Transgrid reference number: 2022-322

Location: : 311 South Street Marsden Park Lot 31 DP 262886

Proposal: South Street Warehousing Estate SSD29668067

Transgrid: 330kV TL14 Sydney North - Kemps Creek Structure 63

TITLE:
PROPOSED SITE PLAN

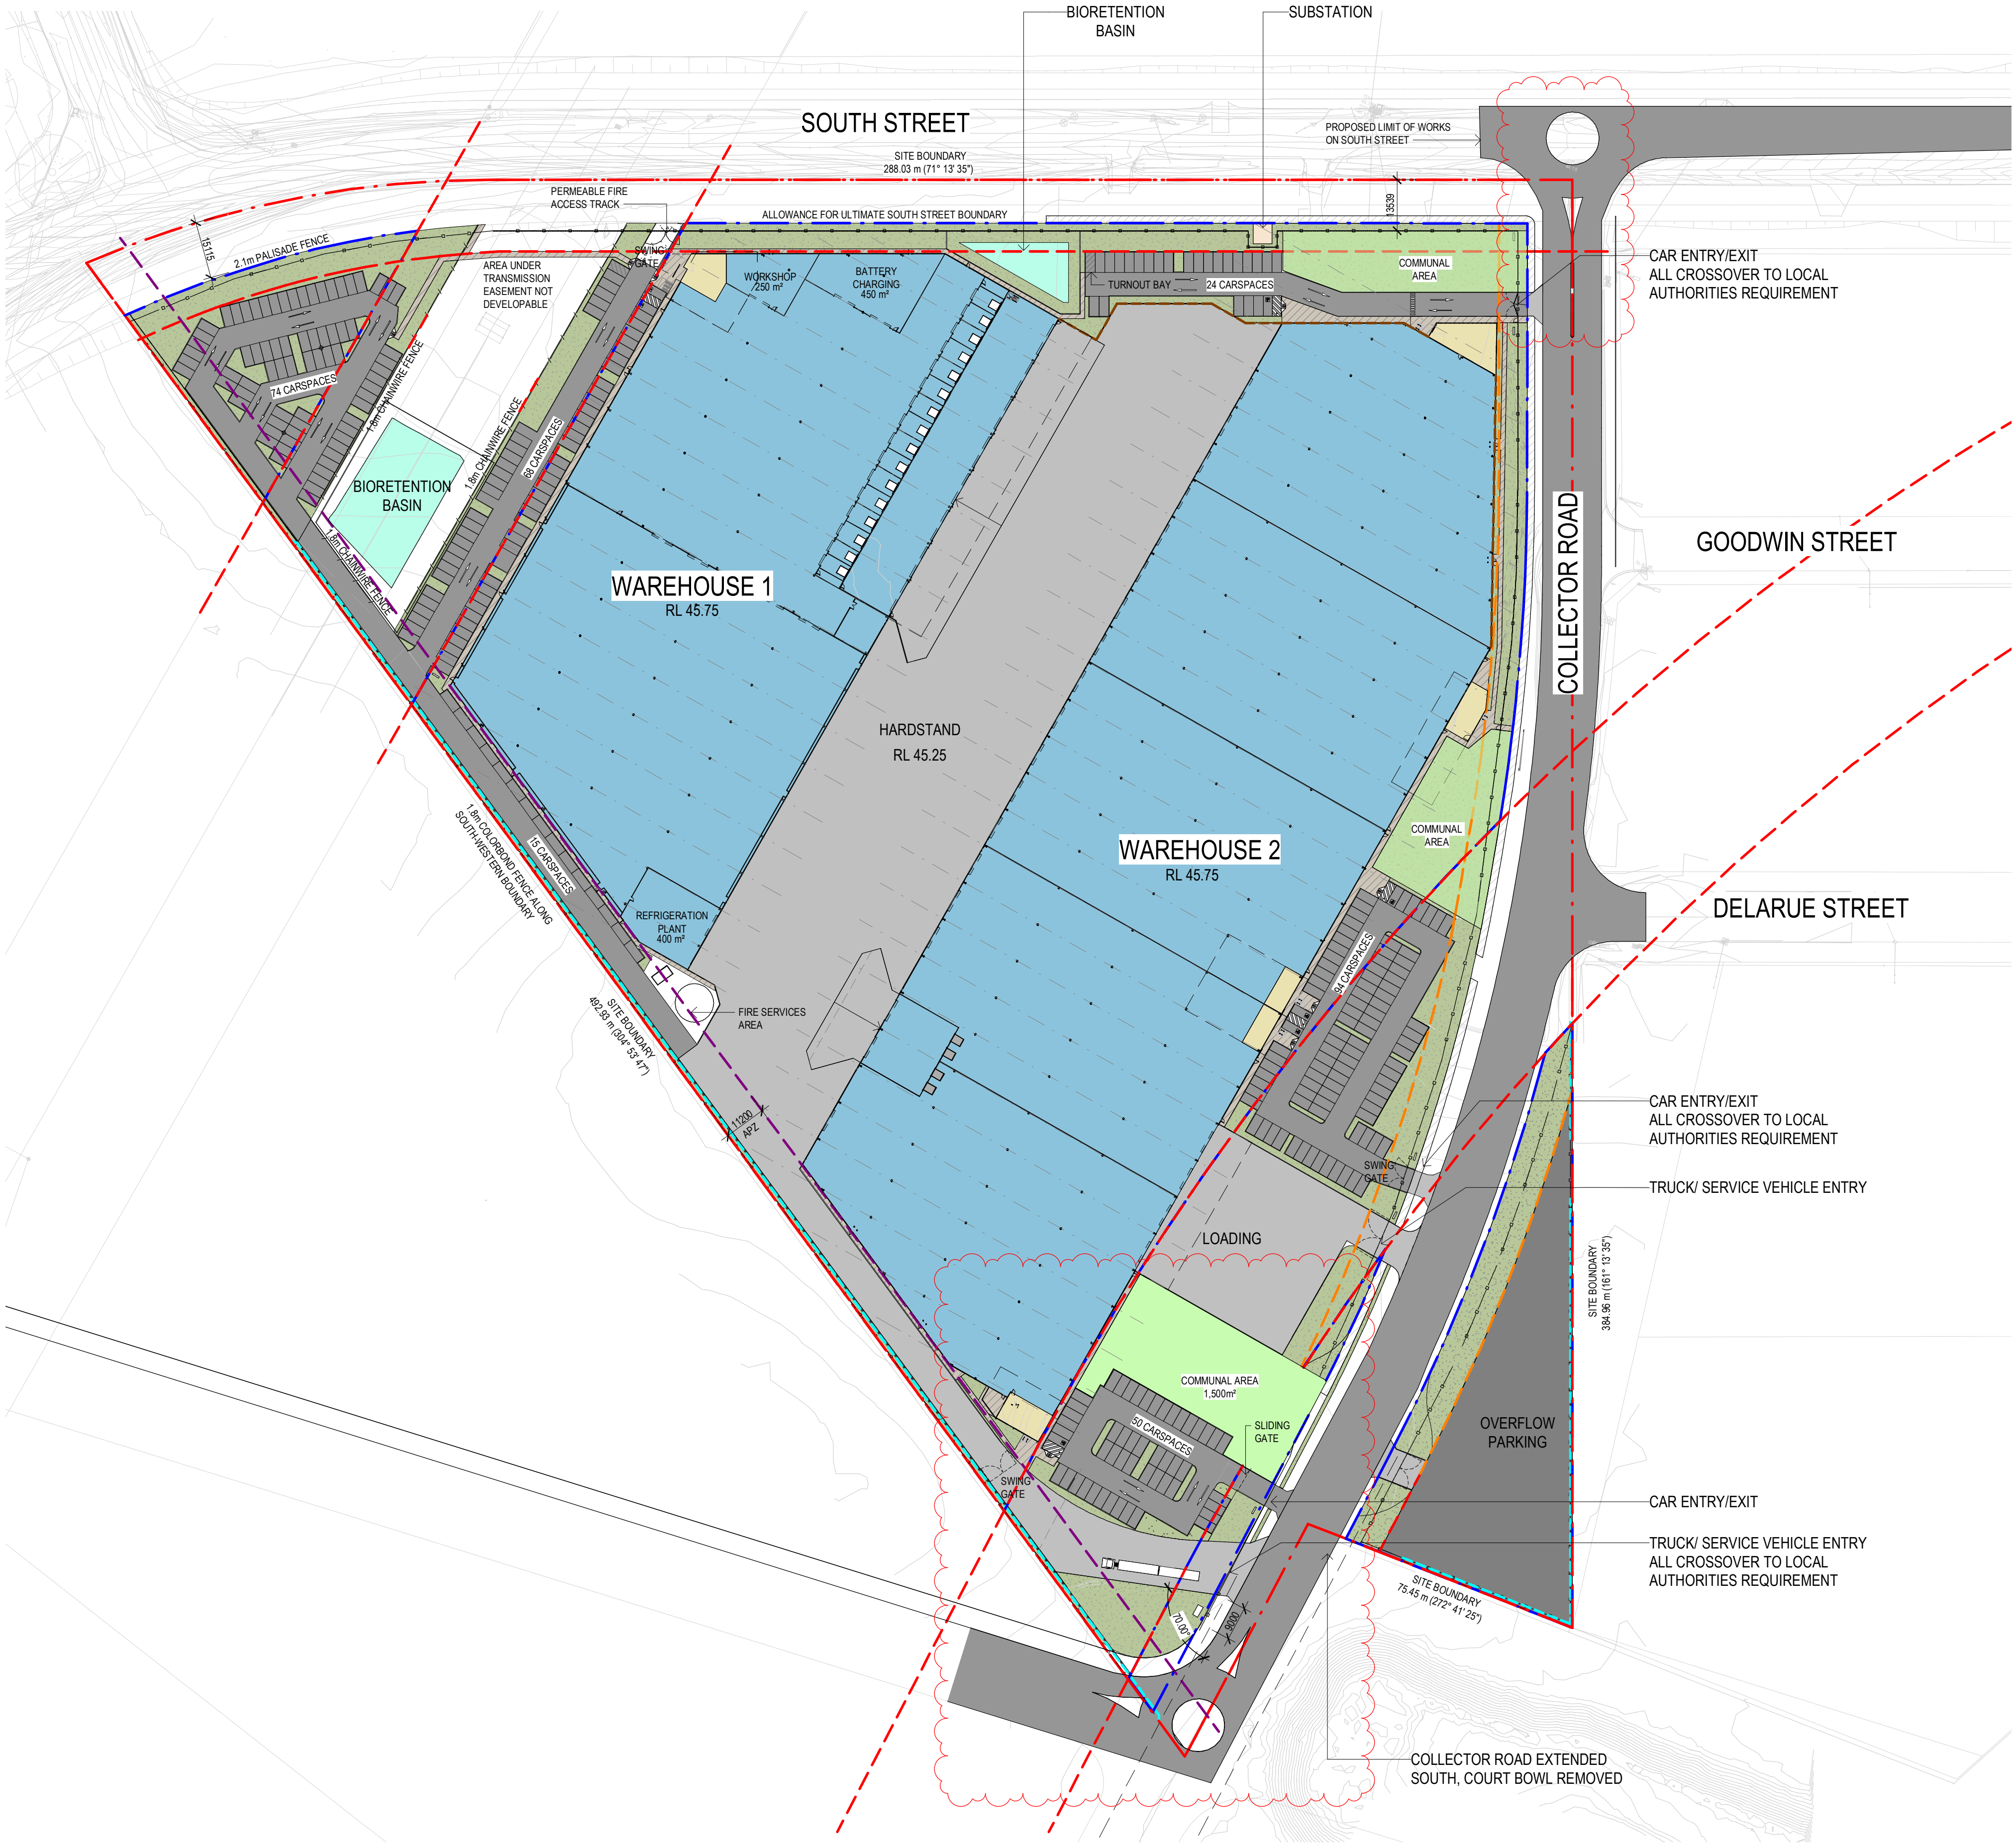
- (1) There is a Transgrid structure within the subdivision
- (2) Car parks and chain wire fence are proposed within the Transgrid structure exclusion zone. Fence is 2.1m high
- (3) No development is proposed within the centreline exclusion zone other than a bio retention basin, which is 33m from the Transgrid structure
- (4) Trees are proposed within the easement

- (5) Road (driveway) crosses the easement, no intersections are in exclusion zone
- (6) Proposed stormwater and other pipes are not detailed

- (1) Car parks, trees and chain wire fence are not permitted within 20m of the transmission tower. Refer mark-up below
- (2) All fencing within the easement must be earthed and isolated as per Transgrid Fencing Guidelines
- (3) Trees within easement shall be no taller than 4m mature height
- (7) No details on services
